CITY OF ALBUQUERQUE

**Re: Lomas Townhouses- 12844 Lomas Blvd NE
Erosion and Sediment Control Plan
Engineer's Stamp Date 12-2-16 (K22E057)**

Erosion Sediment Control Plan

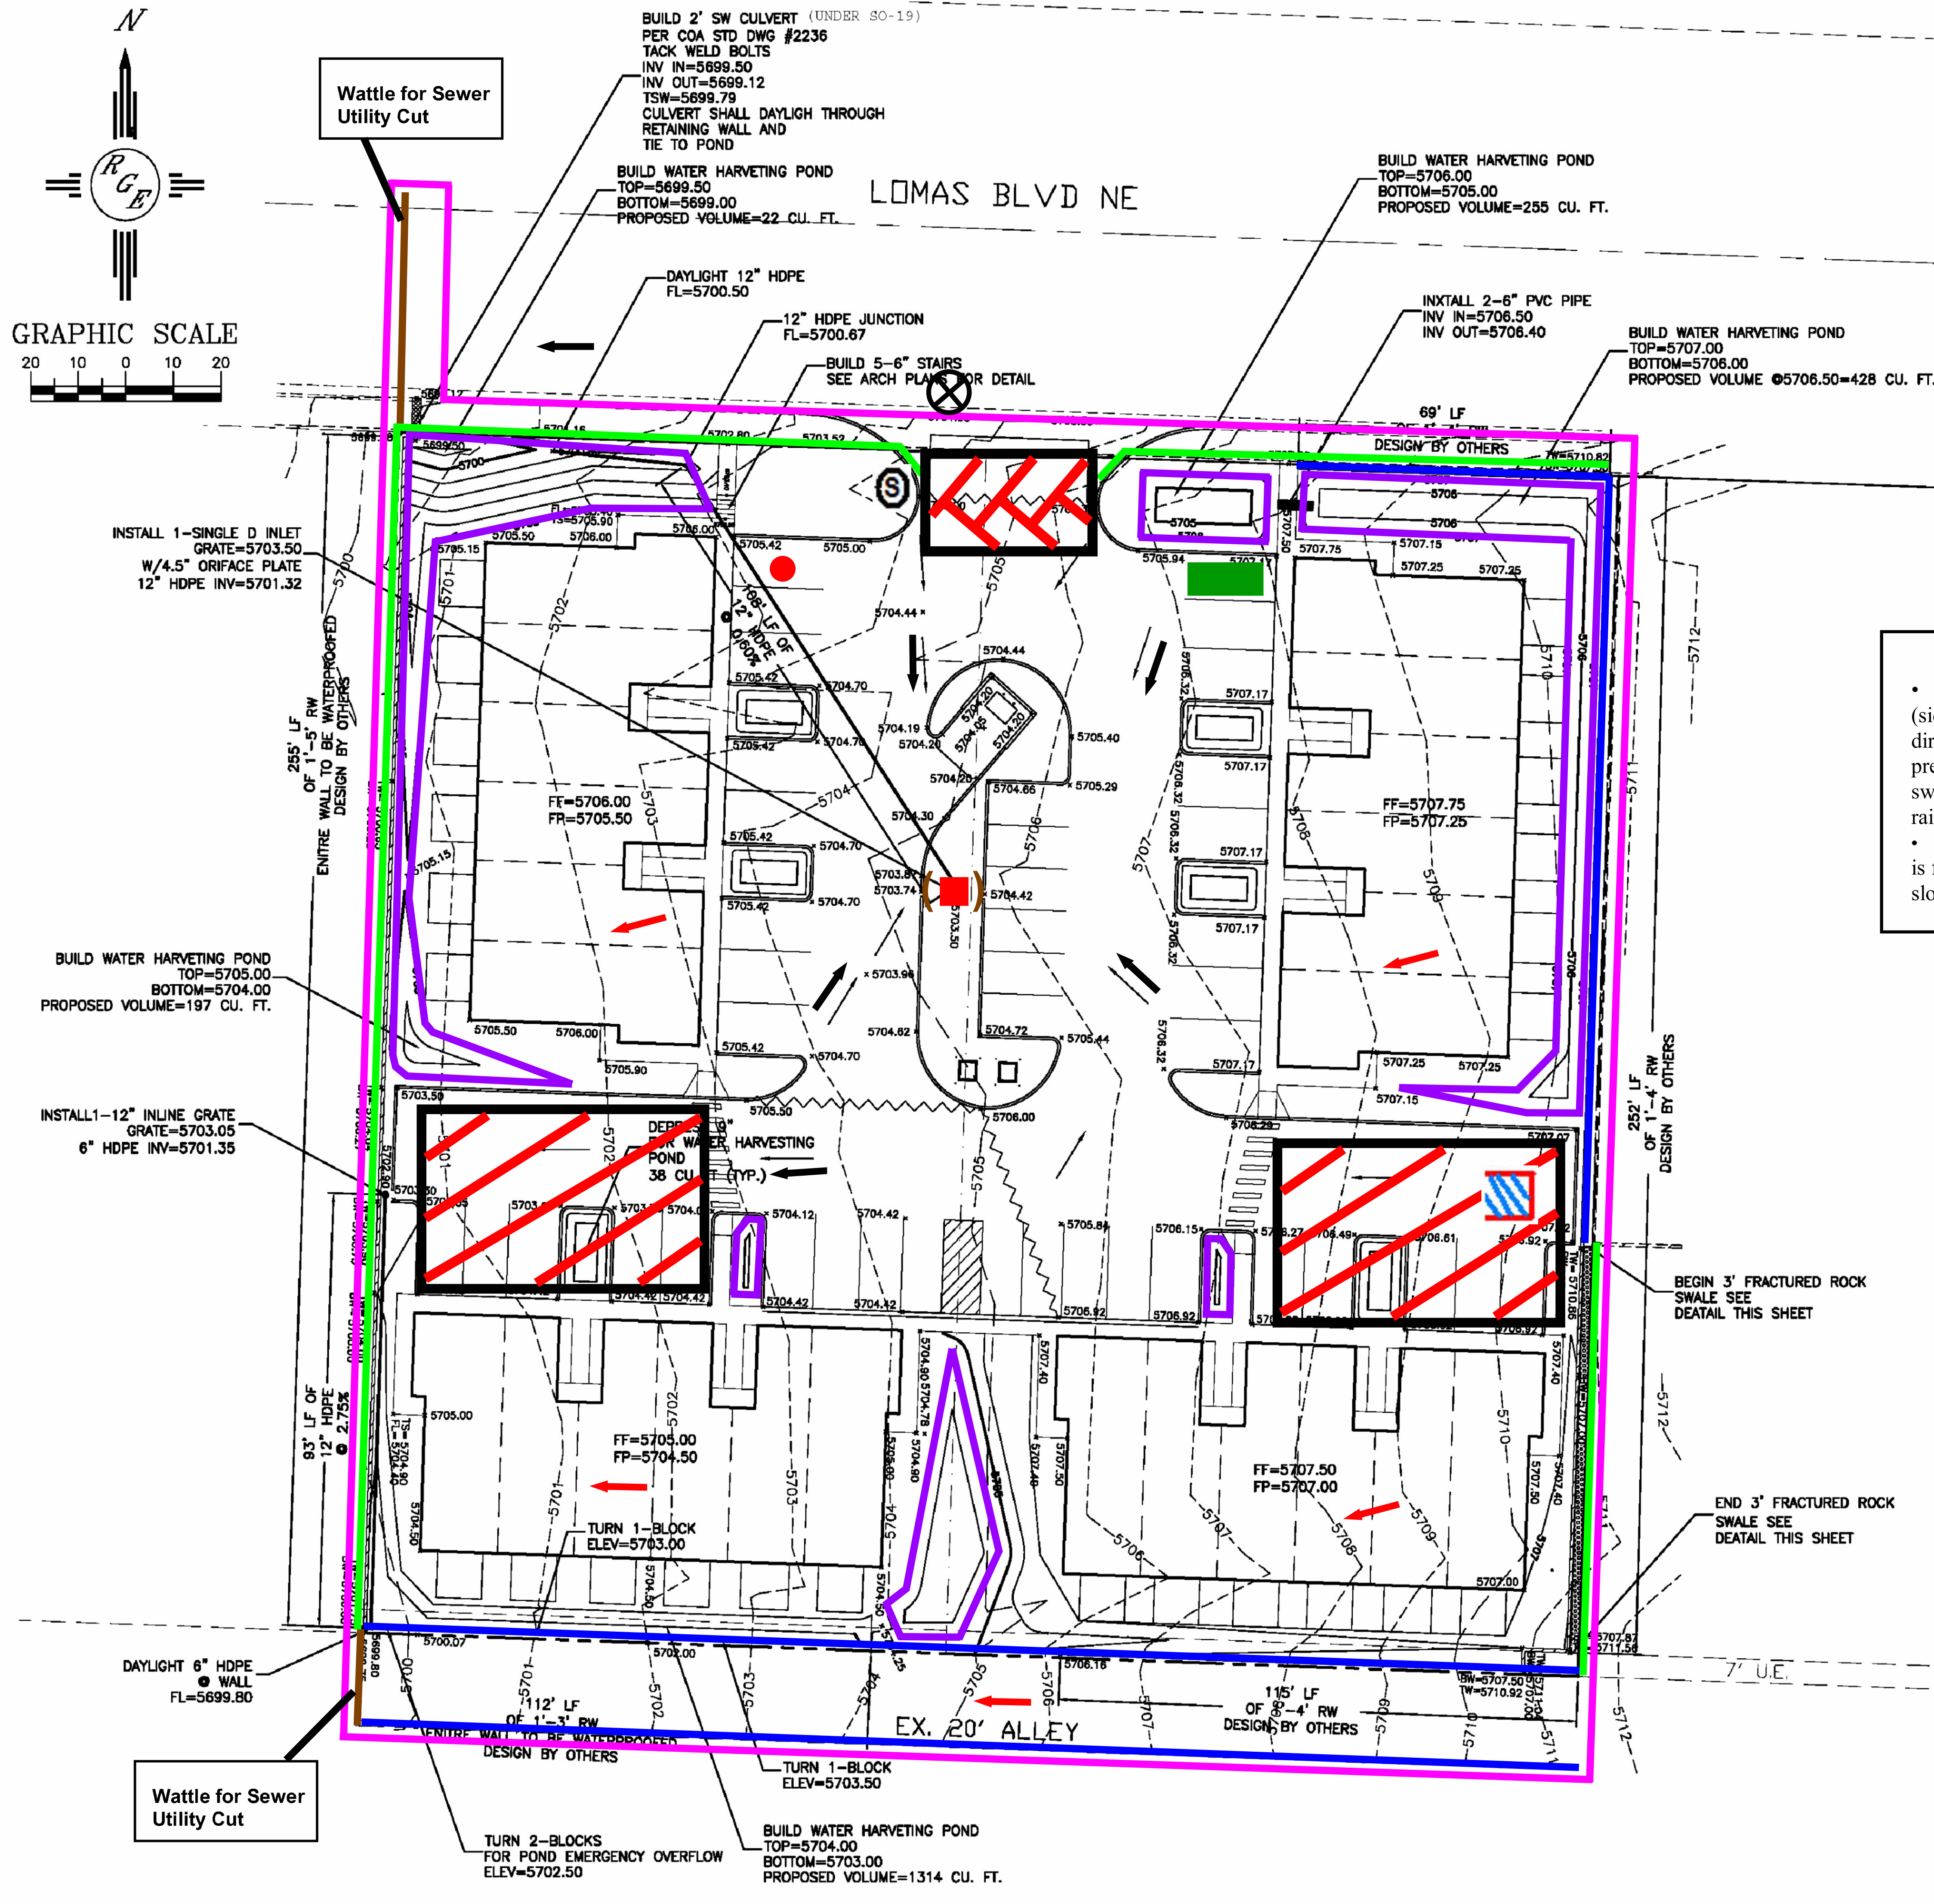
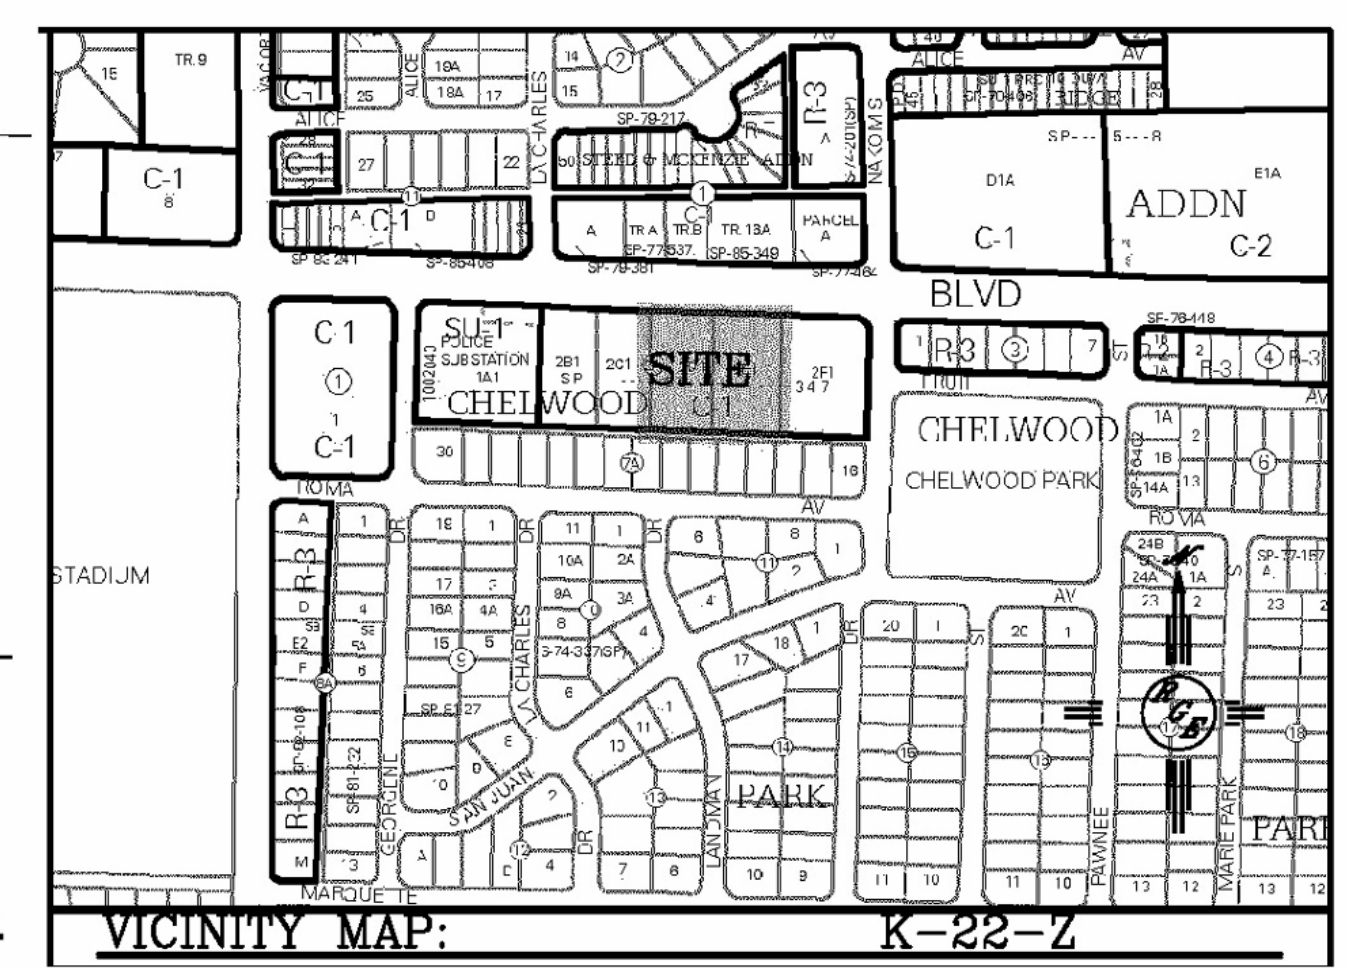
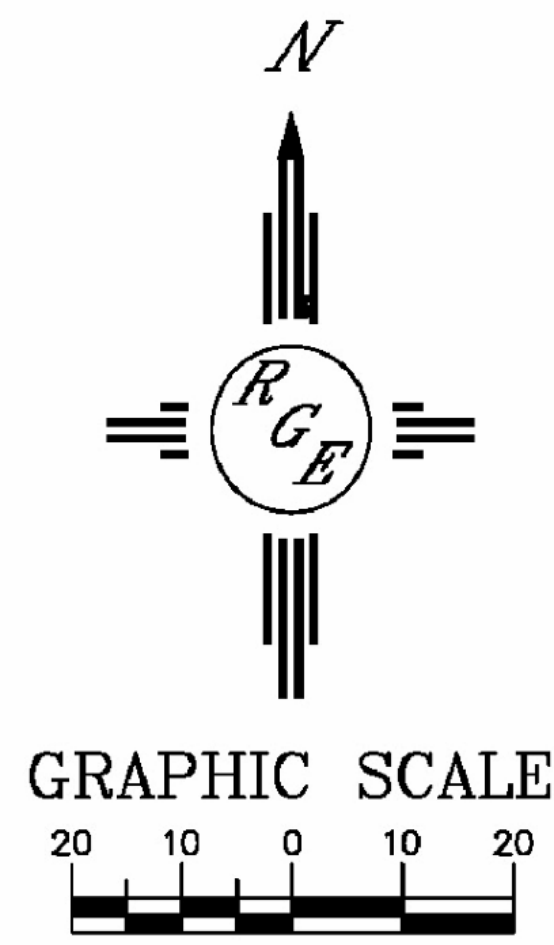
The "Wattle for Sewer Utility Cut" should also be used for the grading that will occur in the alley or the silt fence could be extended south.
